Consultation Response from Emma Mills KC Landscape	
Application No:	2021/93305 & 2021/93306
Proposed Development:	Change of use and conversion of existing buildings, forming of a split-level six storey development (<i>previously erection of a split-level seven storey extension</i>) comprising a four-storey stairwell, four-storey roof-top tower block (<i>previously five-storey roof-top tower block</i>) and enclosed courtyard to form 25 dwellings (<i>previously 31 residential apartments/dwellings</i>) and sub-division of the retail unit forming 61-63 New Street (Full Planning Application)
Location:	61-65, New Street, Huddersfield, HD1 2BQ
Applicant/Agent:	Acumen Designers and Architects Ltd
Planning Officer	RichardA Gilbert
Date Responded:	14.08.23
Responding Officer:	SF
Responding Ref:	KK131/KK132

Landscape Context and Concept, Landscape Design

FIRST FLOOR PLAN

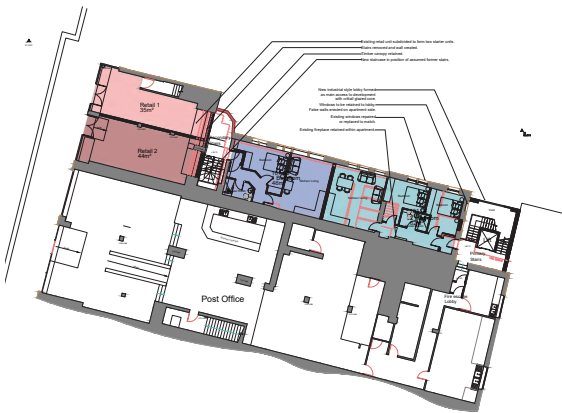
The revised first floor plan ((100)12 Rev B ‘Landscape Scheme shown to courtyard’) shows an internal courtyard comprising private fenced artificially-grassed areas to the maisonettes with a raised planter for shade tolerant climbing plants and trained trees on trellis (highlighted below) along the access path. The plan is very indicative in landscape terms, therefore difficult to provide meaningful comments. We will not consider this as public amenity space. The use of artificial grass is not generally supported, with preference being for small scale natural interventions, however if the provision included SUDs this would have added benefit to slowing the flow.

It is appreciated that there is limited space and light to the area and planting is welcome to soften the appearance of the hard landscaping and provide an attractive backdrop for residents accessing the building by this route. Planting and other screening planting could additionally help the proposed development comply with policies and guidance regarding design, biodiversity, health and wellbeing and other relevant planning considerations. However, more information is required to ensure, ultimately, planting becomes fully established and the proposed landscape scheme is successful. Species choice will be critical given limited natural light levels and space constrictions.

Please submit details of the proposals including: the measurements of the space; dimensions of the planter/s & trellis and soil volumes; a planting plan with species, densities, planting mix, etc.; watering regime and how they will be managed and maintained in the long-term. Espalier trees are suitable where space is limited, but their establishment and management needs to be considered — this should include, but is not limited to, a watering regime, monitoring of ties, formative pruning, replacement of failed or damaged trees.
